WEST SUSSEX COUNTY COUNCIL CONSULTATION

TO:	Arun District Council FAO: Richard Sherman
FROM:	WSCC - Highways Authority
DATE:	29 June 2021
LOCATION:	78 Orchard Way Bognor Regis PO22 9HP
SUBJECT:	BR/131/21/HH Dropped kerb
DATE OF SITE VISIT:	n/a
RECOMMENDATION:	Advice
S106 CONTRIBUTION TOTAL:	n/a

PROPOSED DROP KERB TO 78 ORCHARDWAY BOGNOR REGIS. PO22 9HP. FOR EXISTING DRIVE.

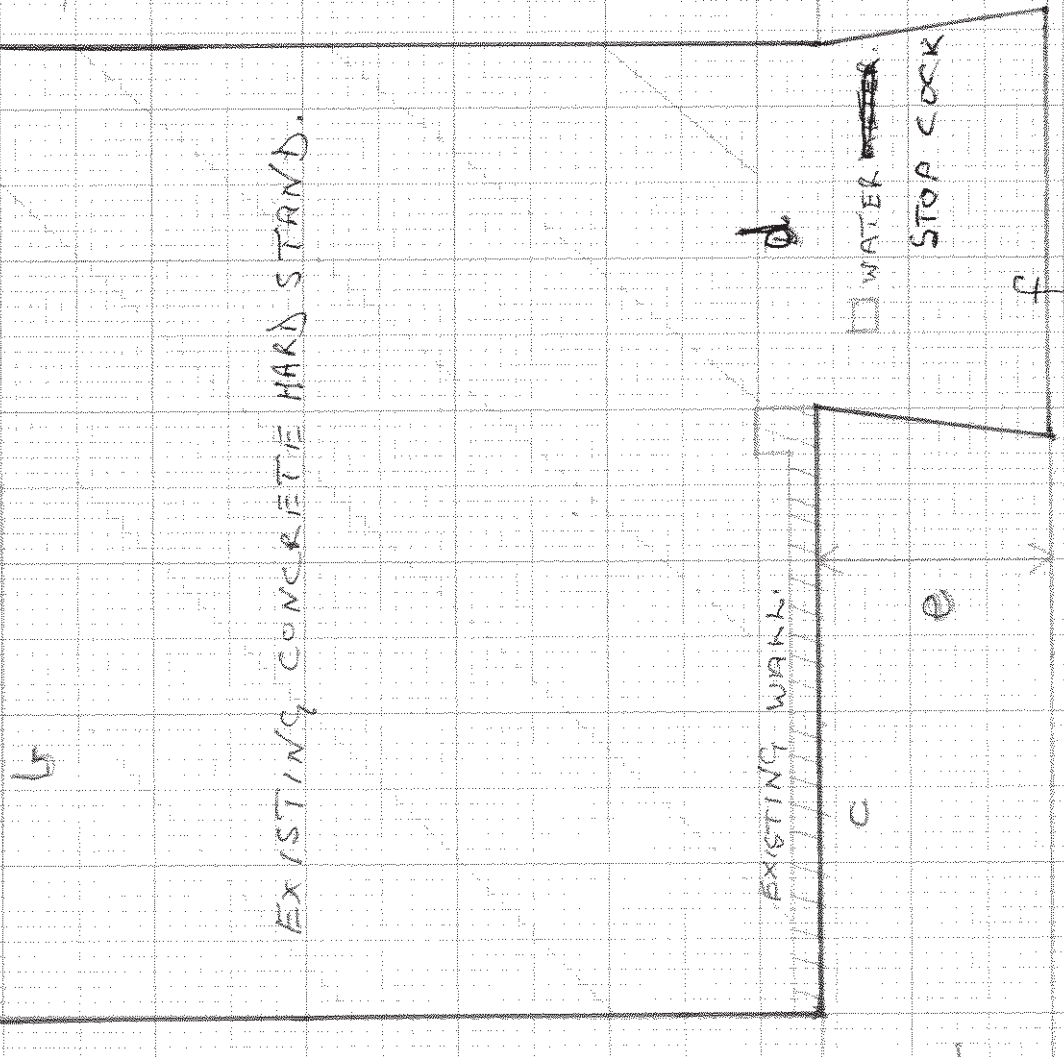
The proposed dropped kerb will be approximately 5.6m in width. The dropped kerb would be subject to a licence from the WSCC Area Engineer and must be constructed to a specification agreed with them.

The proposed plans do not demonstrate visibility at the proposed access onto Orchard Way, however from an inspection of WSCC mapping, visibility appears sufficient for the anticipated road speeds in this location and splays are maintainable wholly within the public highway.

The use of the access shall not commence until such time as the vehicular access serving the development has been constructed in accordance with the approved plan.
